Addendum No. 1

RE: Contract # C204070

Pitt County (U-5606)

SR-1598 (DICKINSON AVE) FROM NC-11 TO SR-1610 (READE CR)

PROJECT REFERENCE NO. U-5606	SHEET NO. E-11
SHEET TITLE: STREET LIGHTING PLAN

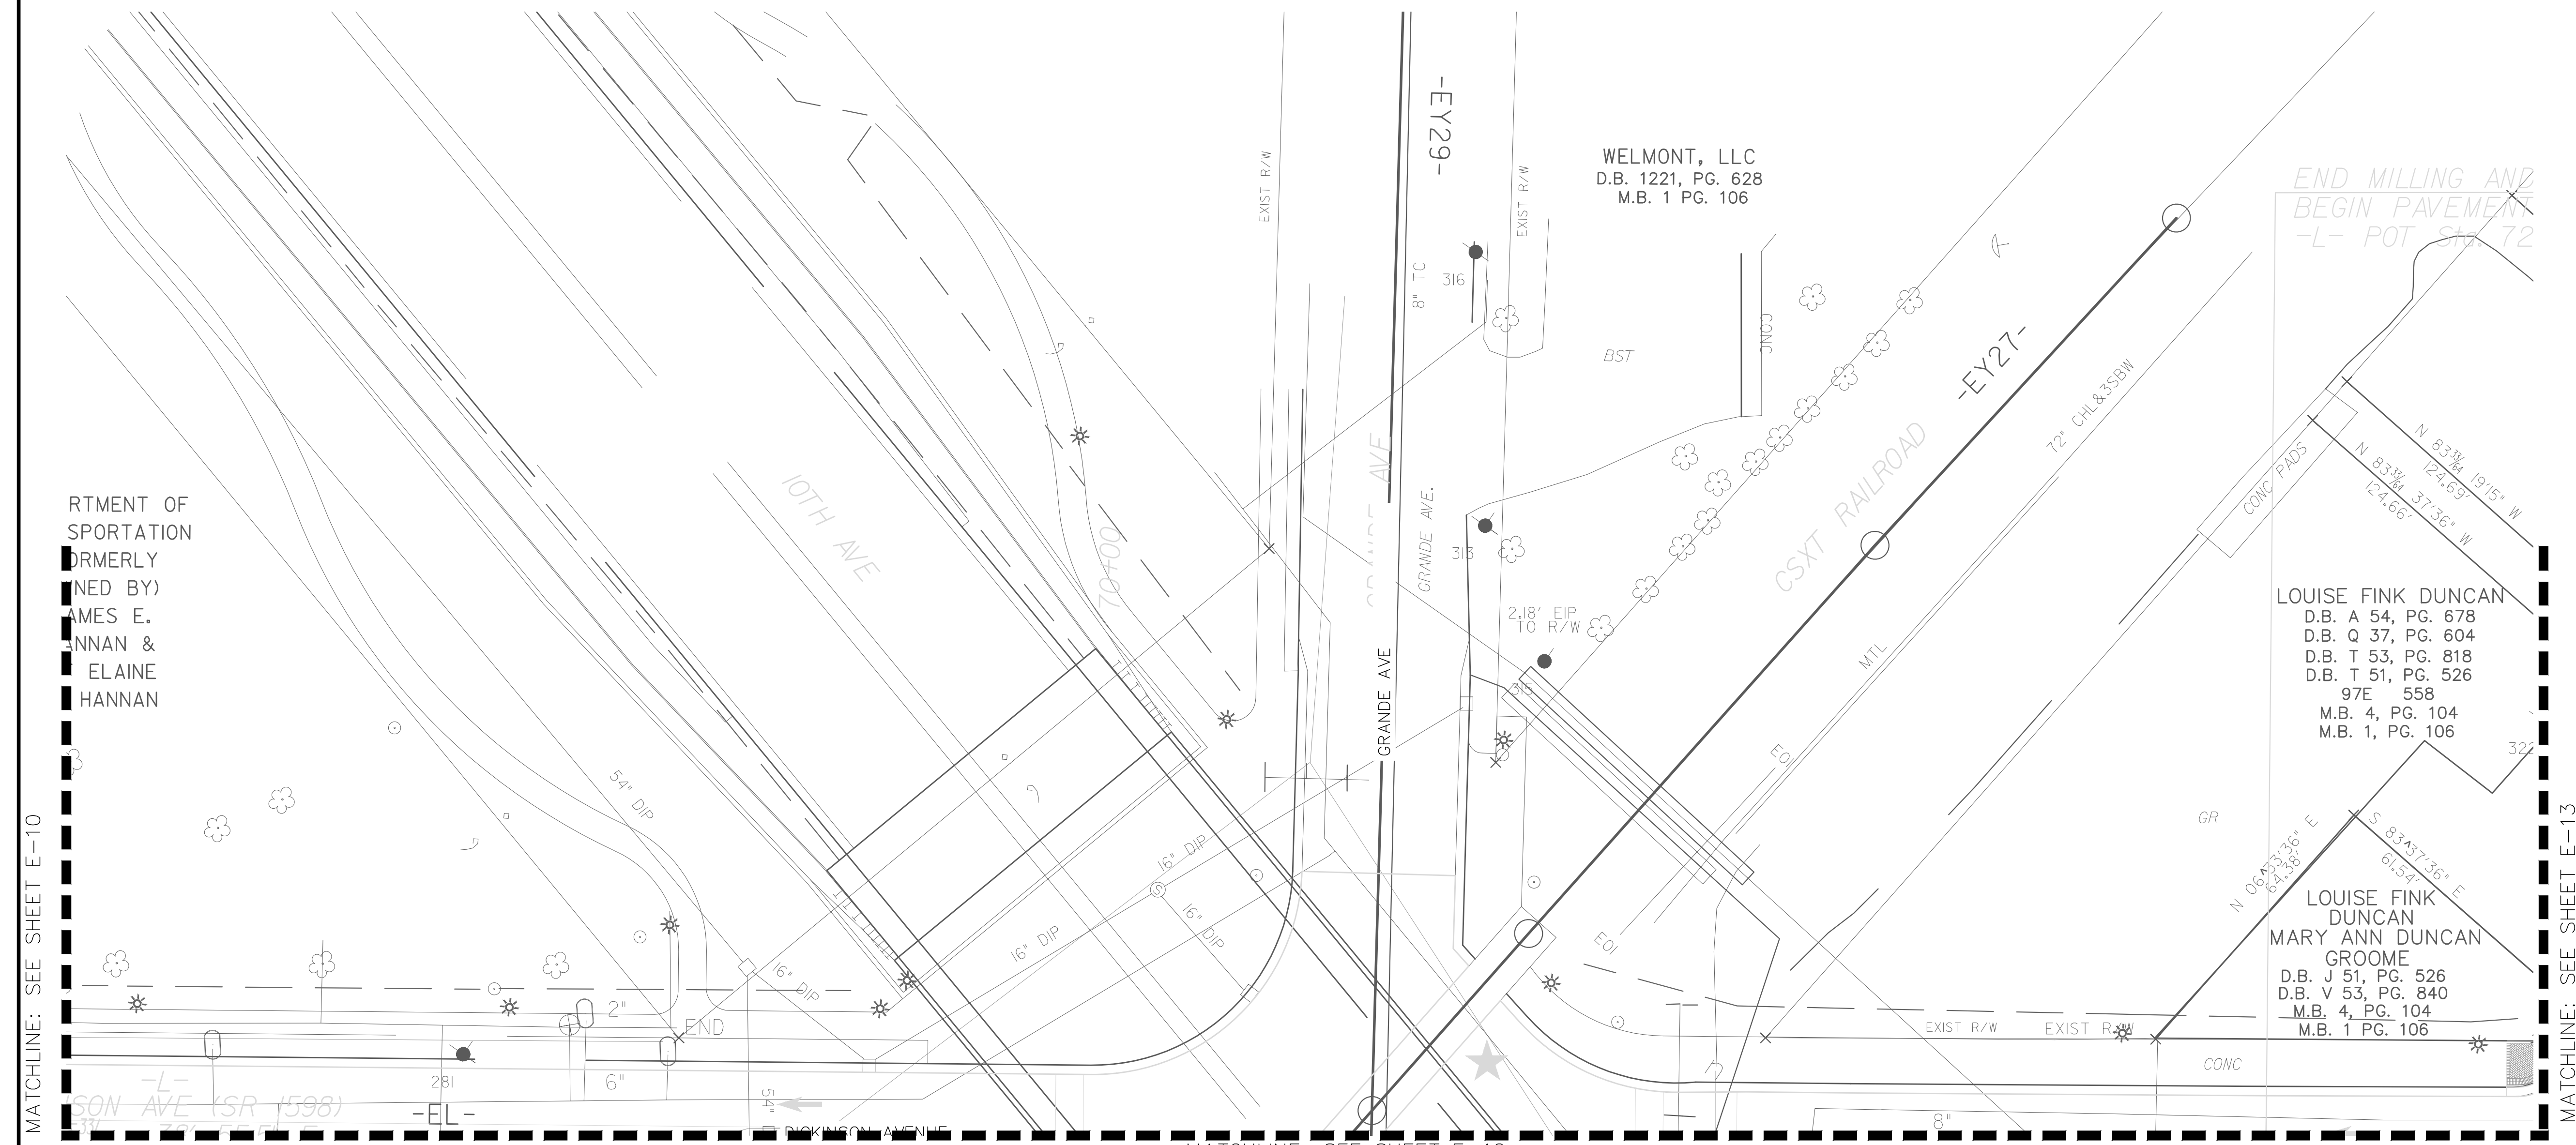
Sheet No.	Revision
E-1 thru E-15	Revised General Lighting Notes
E-2 thru E-10 & E-13 thru E-15	Revised electrical conduit layout
E-9 & E-10	Revised light pole layout
E-16	Revised light fixture schedule
E-17	Revised junction box schedule
E-19	Revised post mounted receptacle detail
